Rezoning Transportation Analysis

Petition Number: 2021-100

Date	Description
8-20-2021	First Review (DBS)
9-22-2021	Second Review (BKB)

The site is located at the intersection of Eastfield Road and Independence Hill Road, both State-maintained minor thoroughfares. A Traffic Impact Study (TIS) is not needed for this site. Site plan revisions are needed to meet ordinance requirements and the outstanding items including, but not limited to labeling and dimension right-of-way and existing and proposed streetscape elements. Further details are listed below.

CONCEPT
SITE PLAN

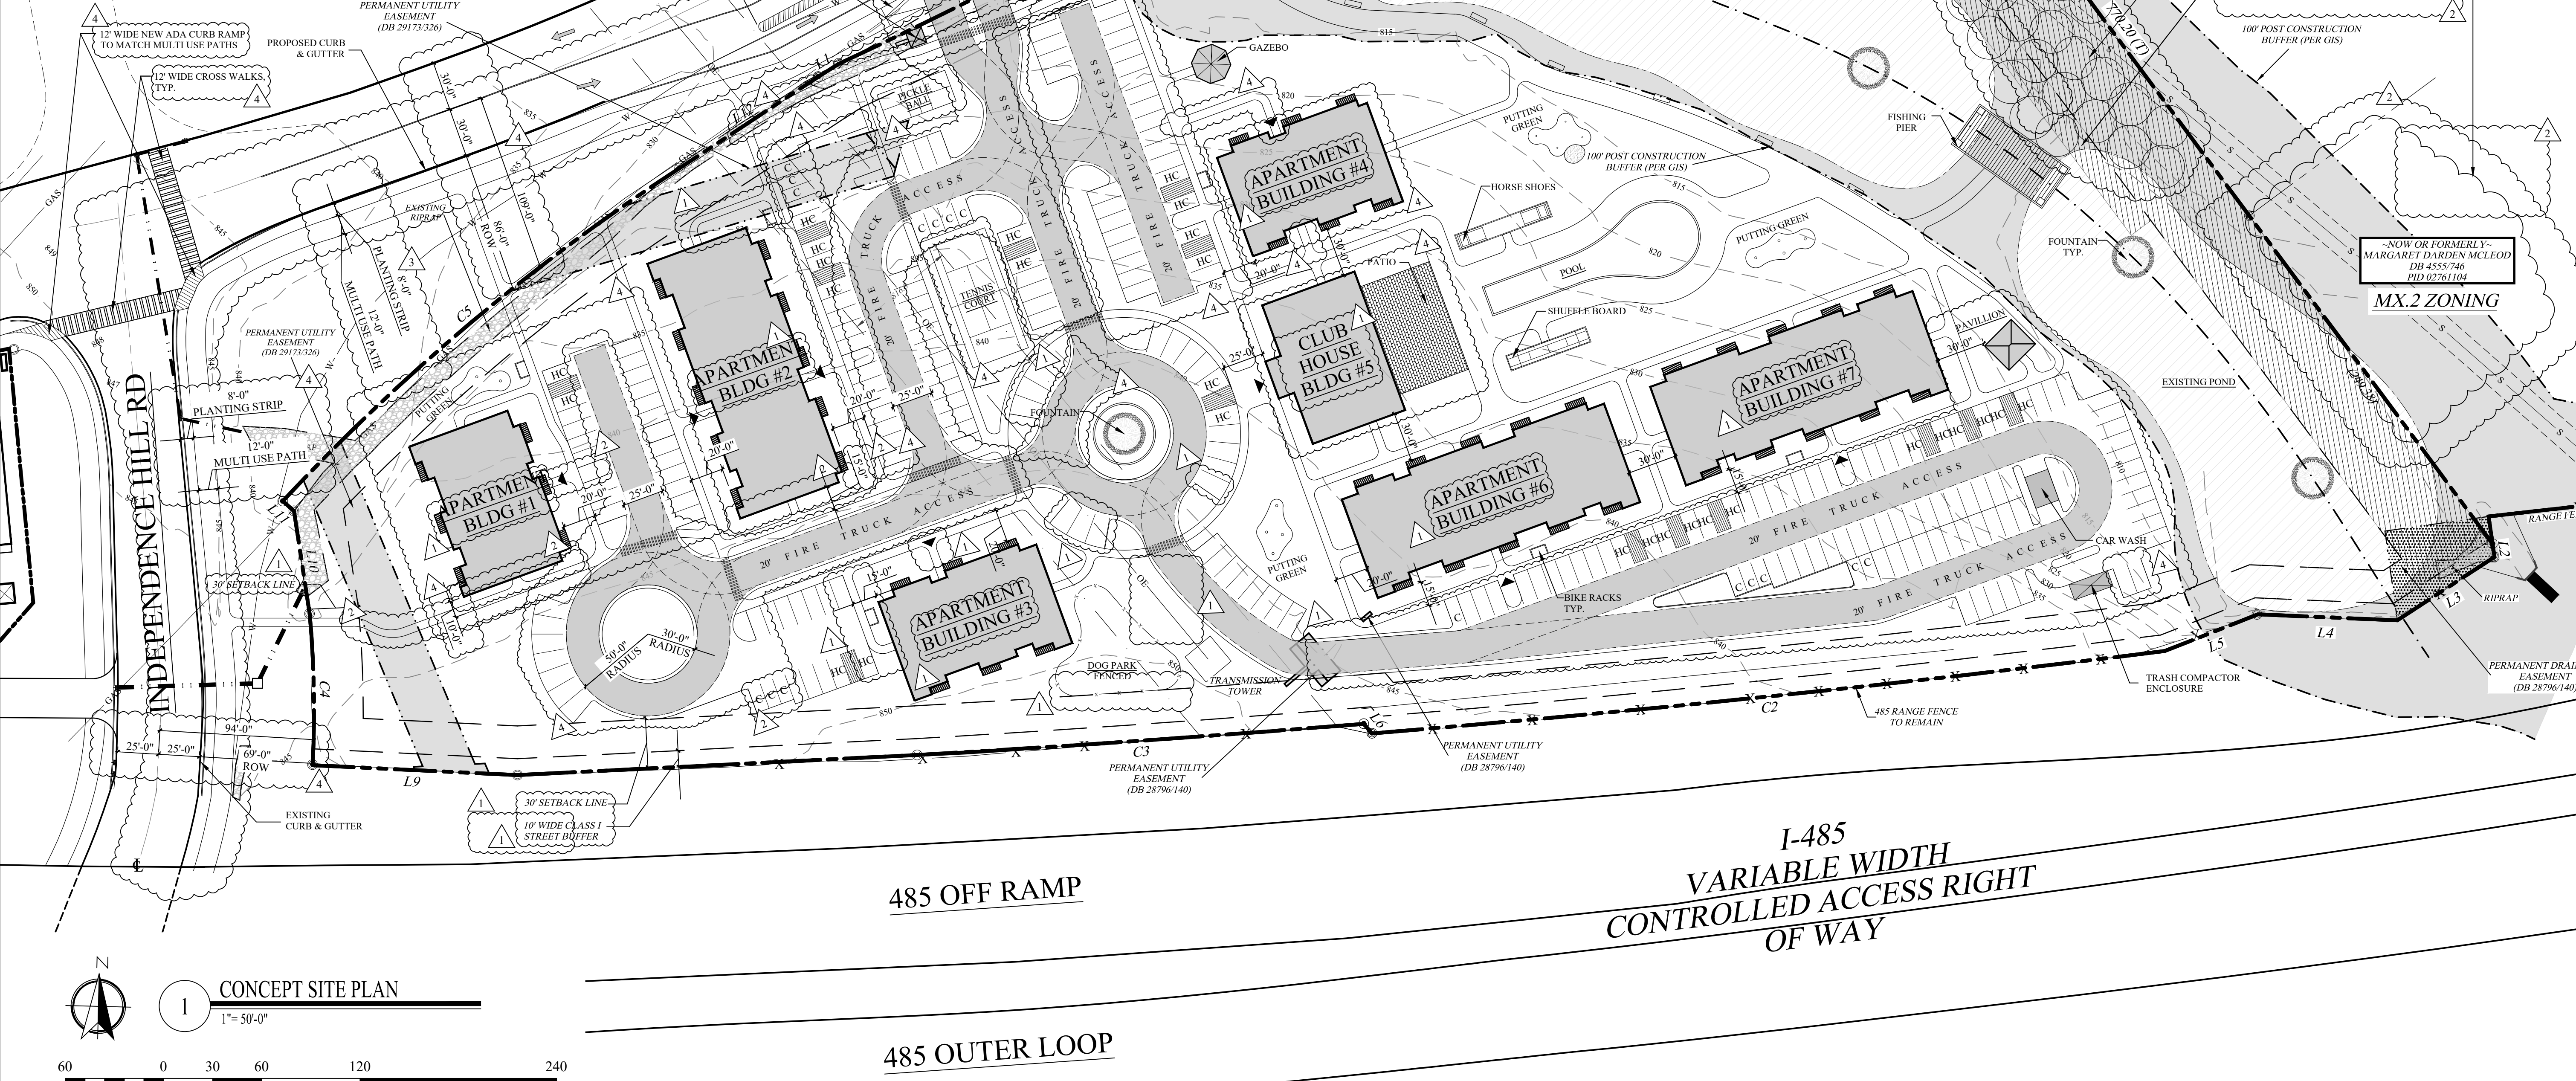
1. The curbline along Eastfield Road shall be shown at 30' from centerline to back of curb. Revise site plan to reflect this condition and label and dimension the right-of-way and curb and gutter from the Eastfield Road centerline.
Outstanding Comment from 8-20-21: Show proposed curb and gutter along Eastfield Road and provide dimension showing 30' from centerline to back of proposed curb.

3. Revise site plan and conditional notes to label and describe location of the existing curb location and right-of-way along Independence Hill Road. The site plan shall label and dimension the curb and right-of-way from the road centerline.
Outstanding Comment from 8-20-21: Show proposed curb and gutter along Independence Hill Road and provide dimension from centerline to back of proposed curb.

4. Revise site plan to construct 8-foot planting strips and 12-foot multi-use paths on Eastfield Road and Independence Hill Road. The site plan shall label and dimension both items from the back of curb and gutter and road centerline. Add conditional note committing to construction and maintenance of the 8-foot planting strips and 12-foot multi-use paths on Eastfield Road and Independence Hill Road since property is in the ETJ. A maintenance agreement will be required for these facilities.
Outstanding Comment from 8-20-21: Current plan shows 4' back of curb sidewalk along Eastfield and Independence Hill Roads. Revise site plan to construct 8-foot planting strips and 12-foot multi-use paths on Eastfield and Independence Hill Road frontages. Add conditional note committing to construction and maintenance of these facilities.

6. Revise site plan and add conditional notes showing access points off of Eastfield Road and Independence Hill Road to be right in-right out only.
Outstanding Comment from 8-20-21: Add conditional note under Transportation denoting access points off of Eastfield Road and Independence Hill Road to be right in-right out only.
